From: [Weston Parish Council](#)
To: [Great North Road Solar](#)
Subject: Weston Parish Council comments Solar Farm in Newark & Sherwood Notts
Date: 08 December 2023 08:10:45

Comments from individual Councillors (1 abstained):
"Environmental impact assessment scoping - Great North Road Solar Park

1:30,000 Scale @ A3

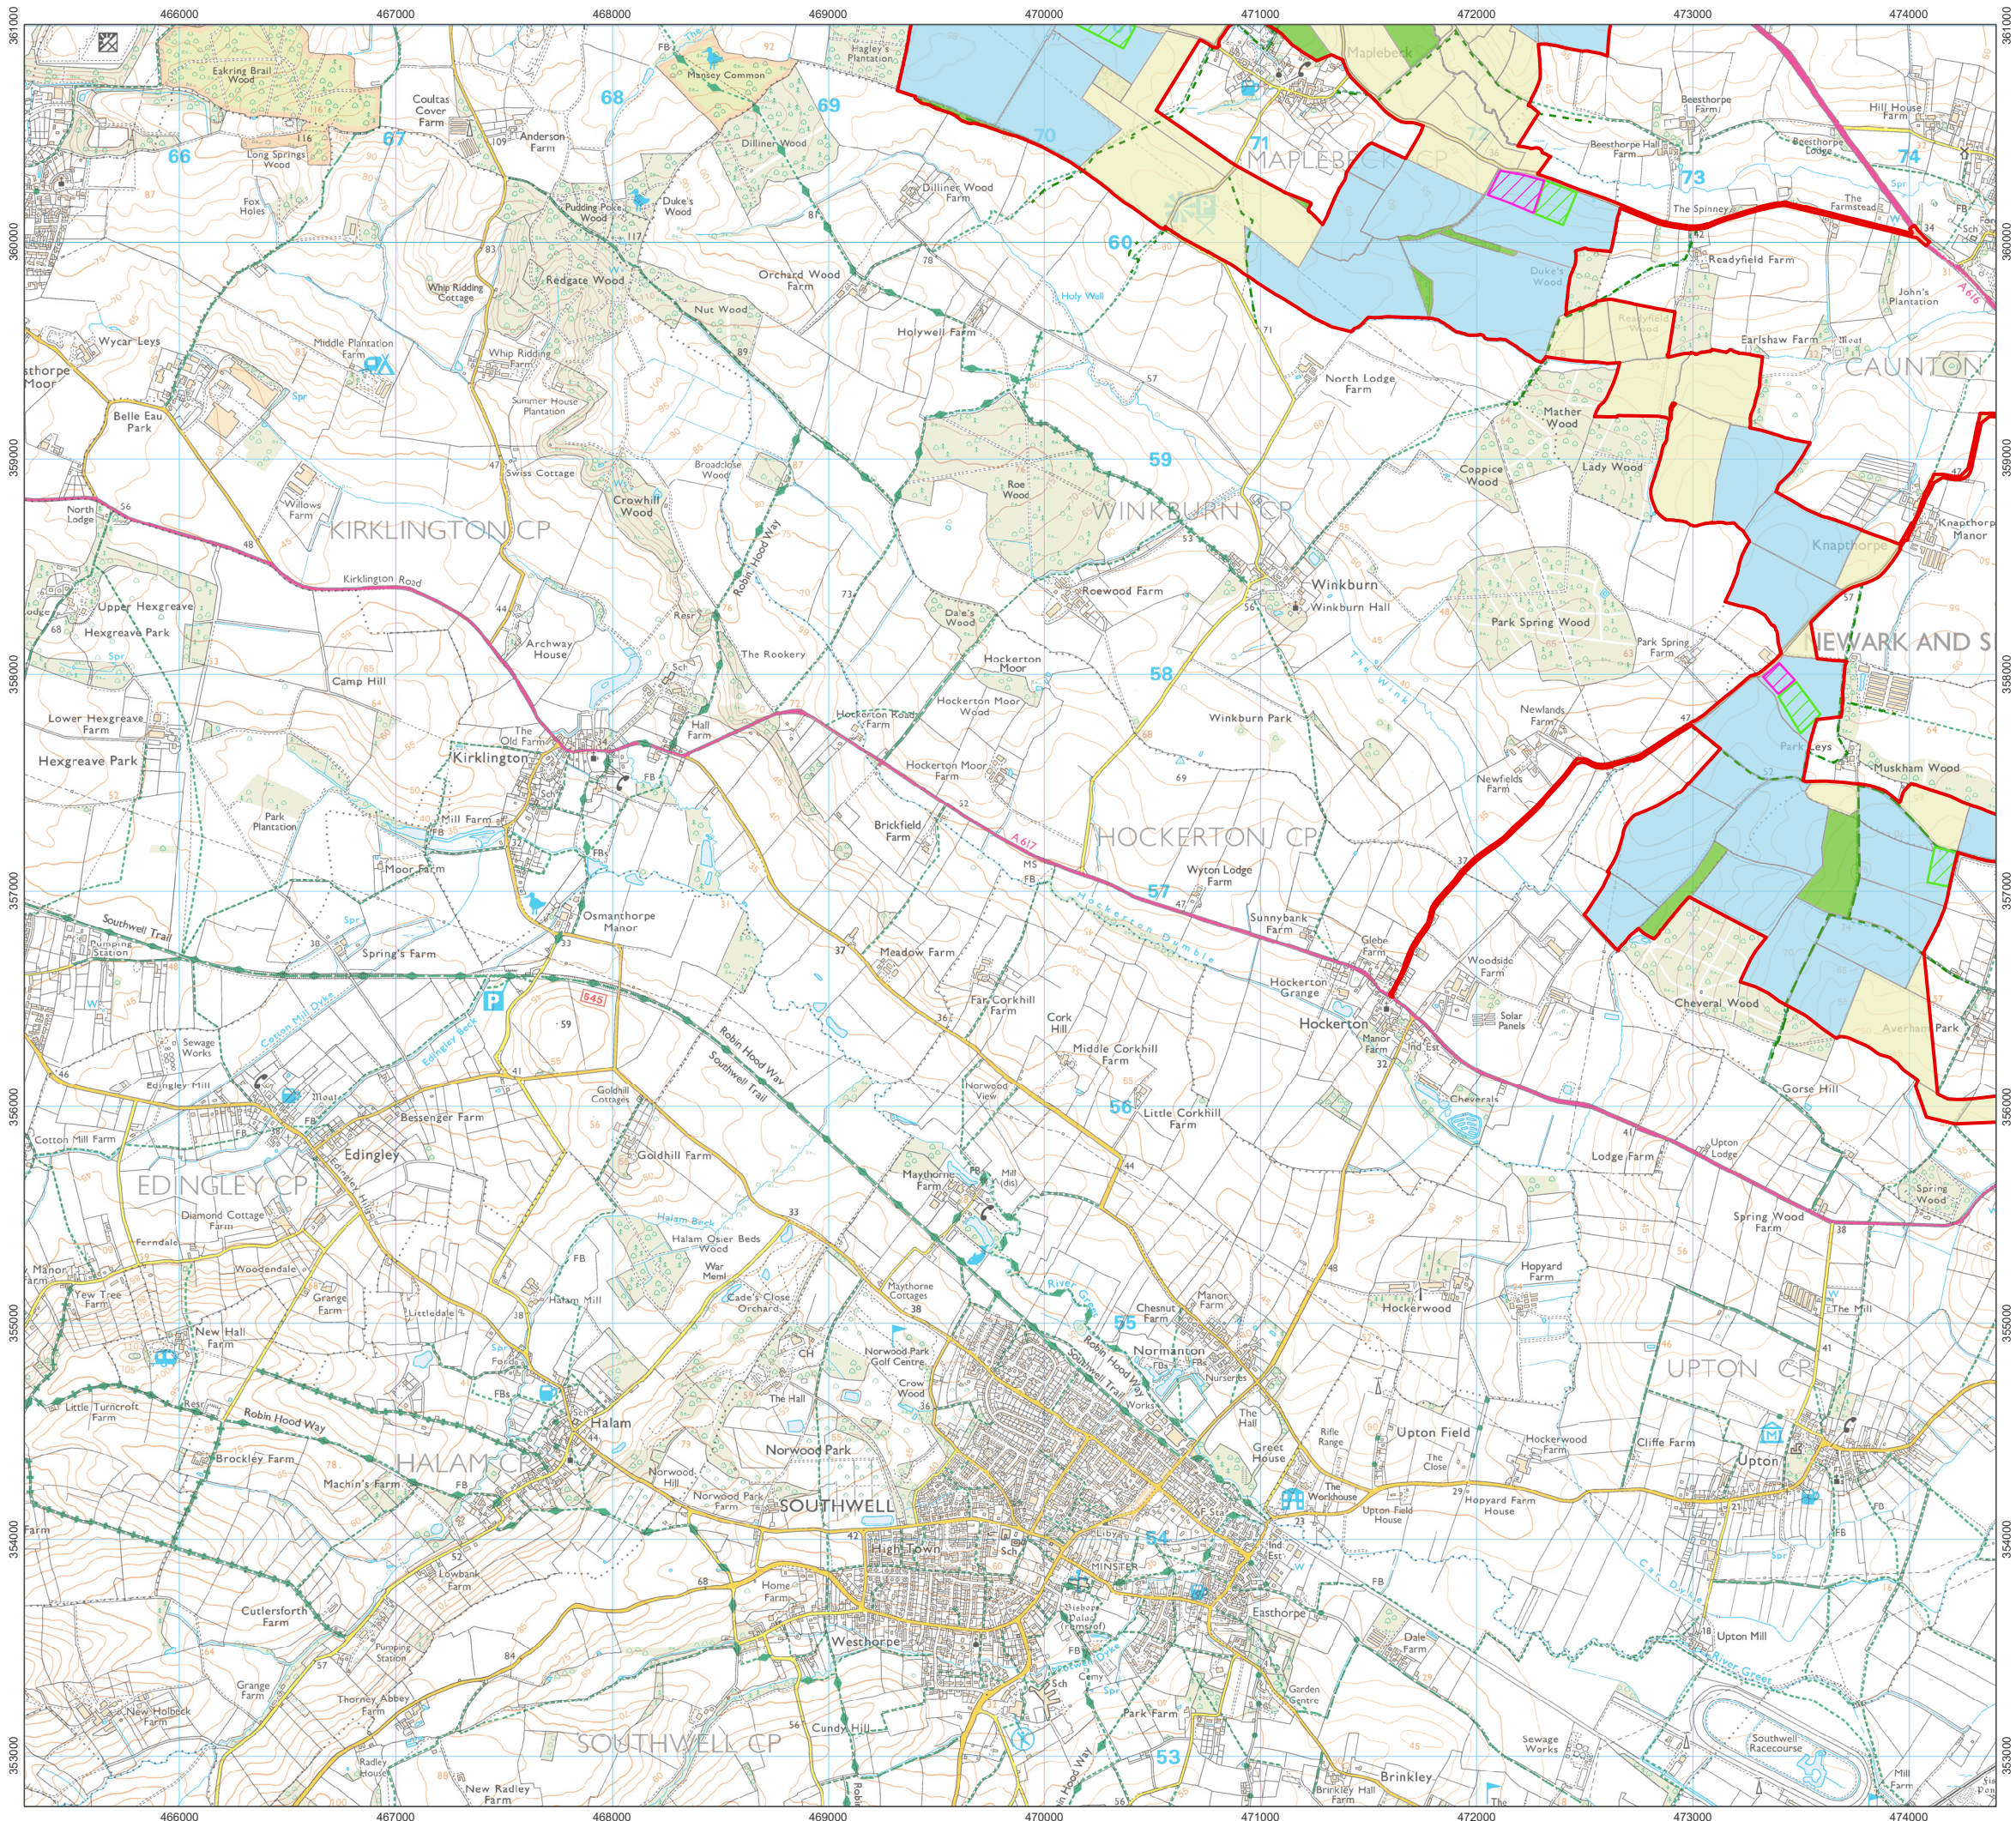
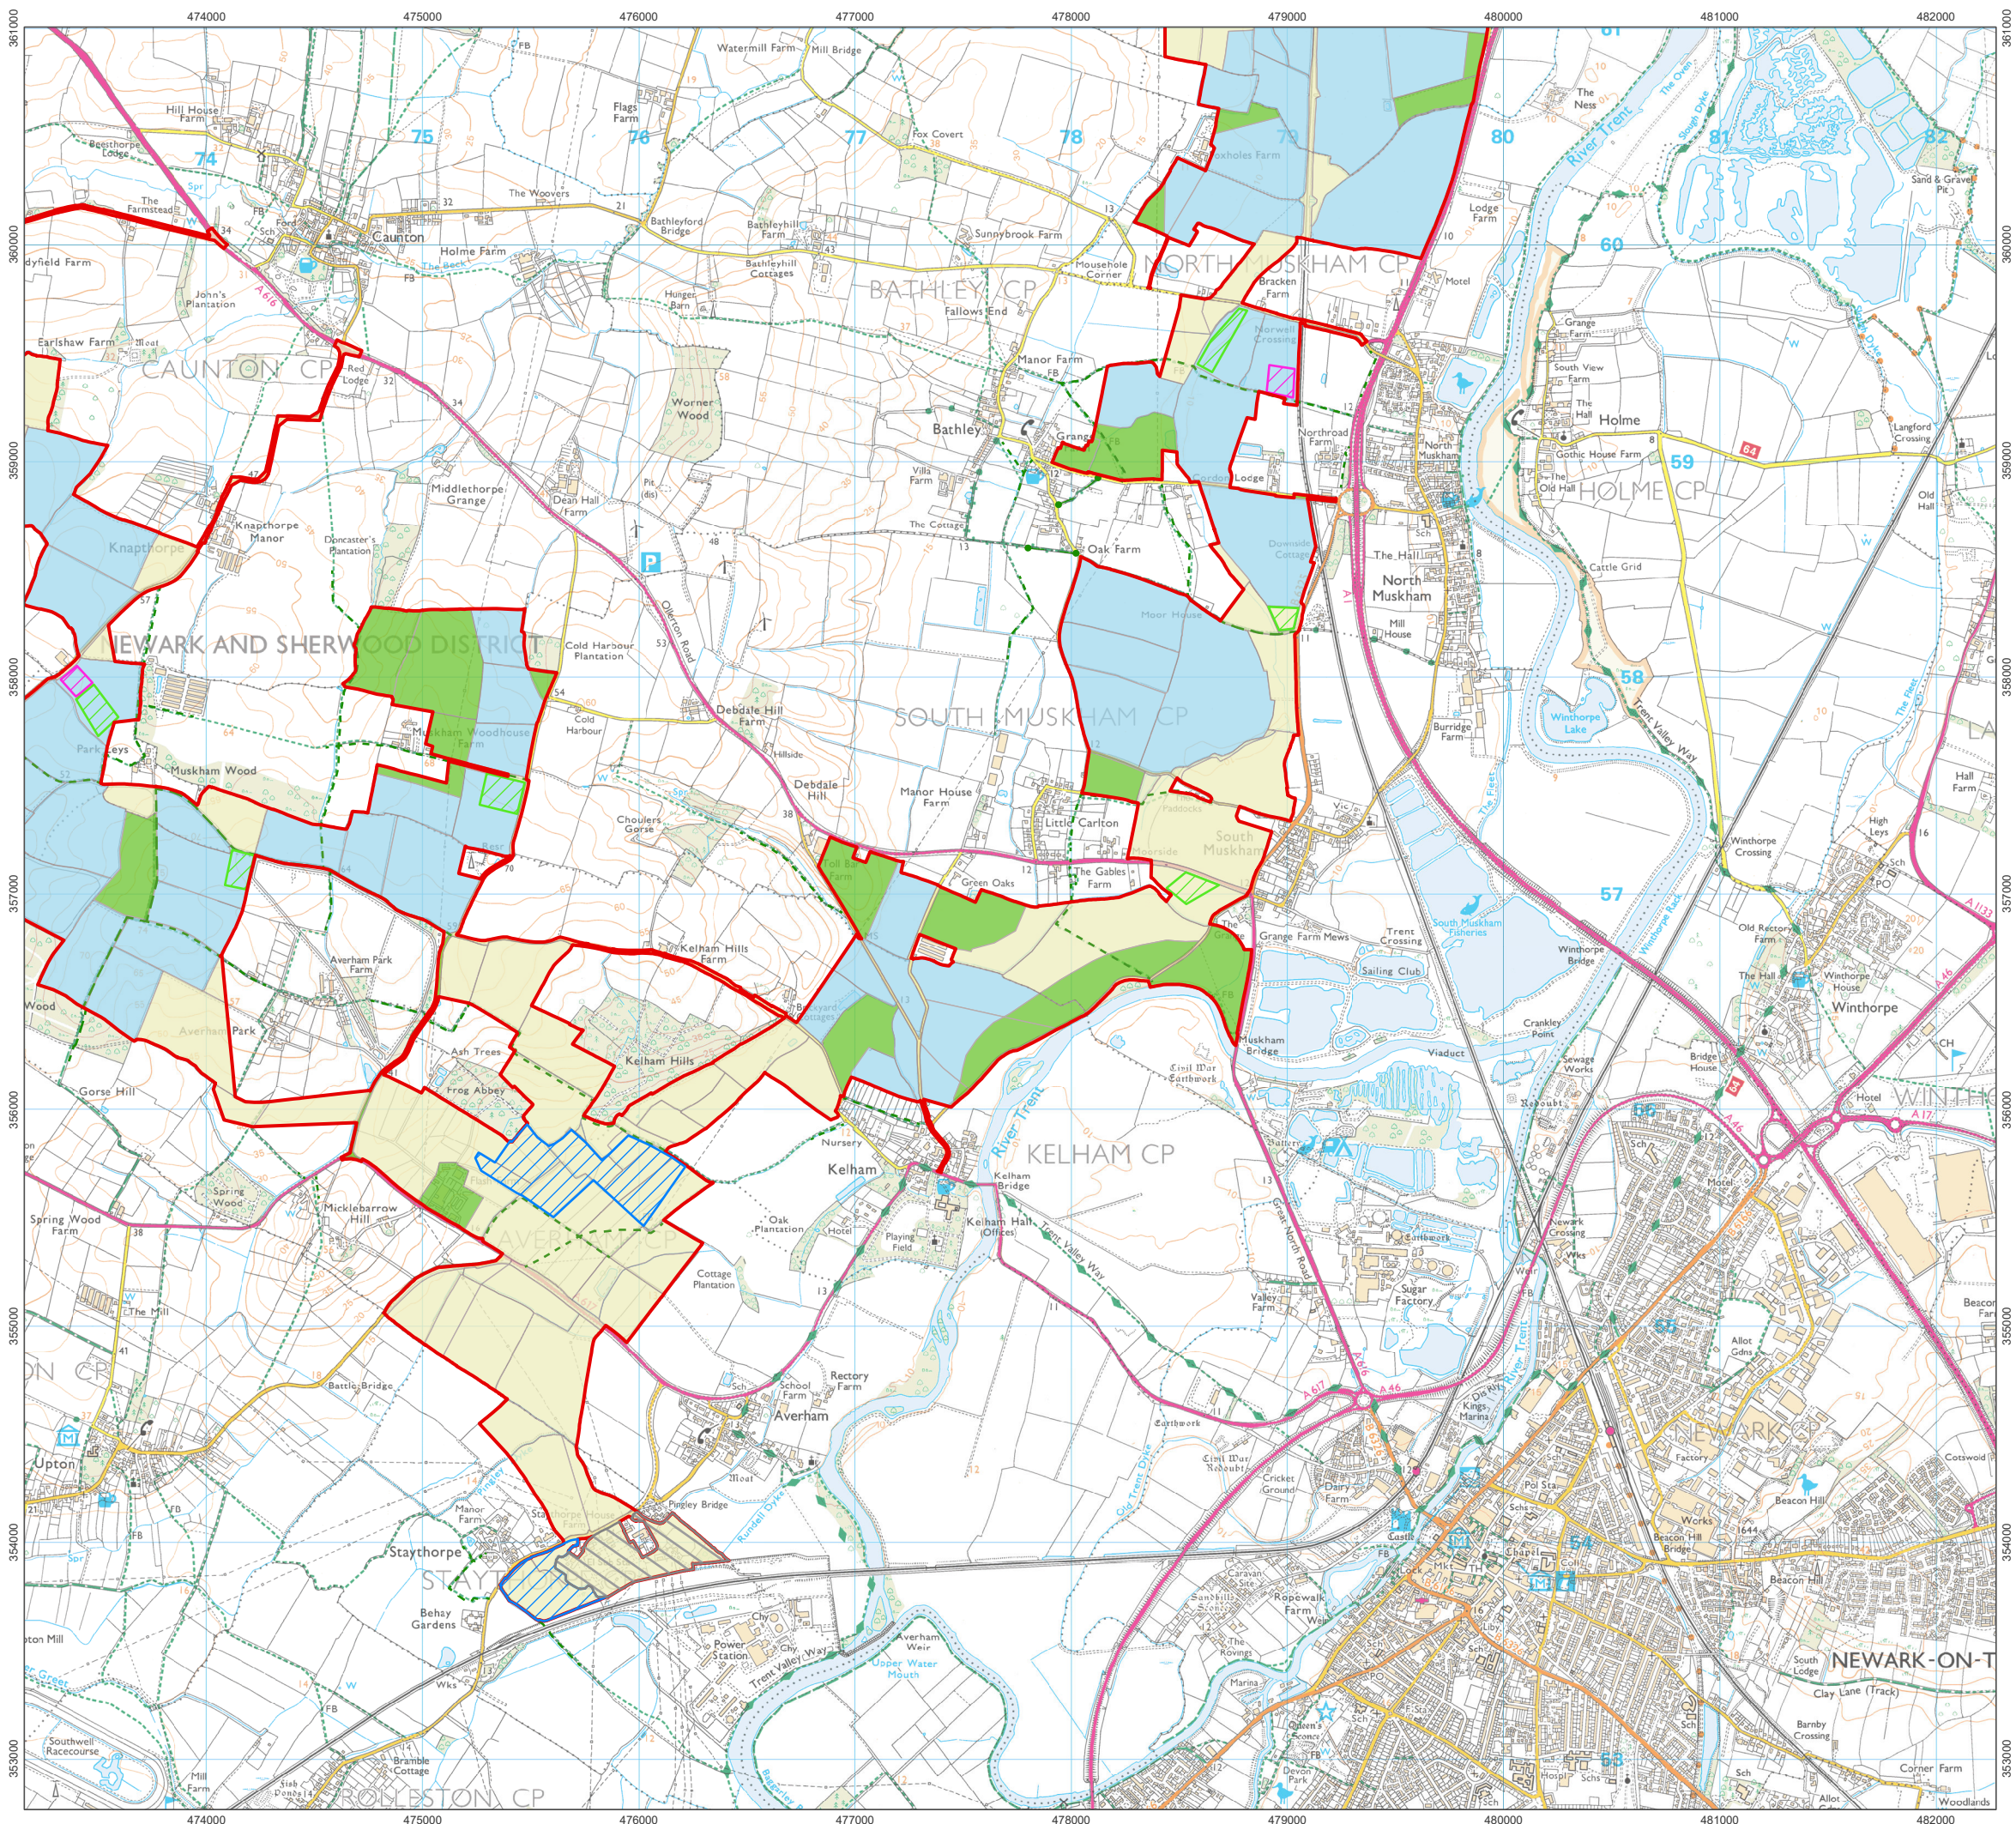
Disruption to walkers and horse riders to footpaths and bridleways during construction phase. Nine footpaths and one bridleway will be affected.
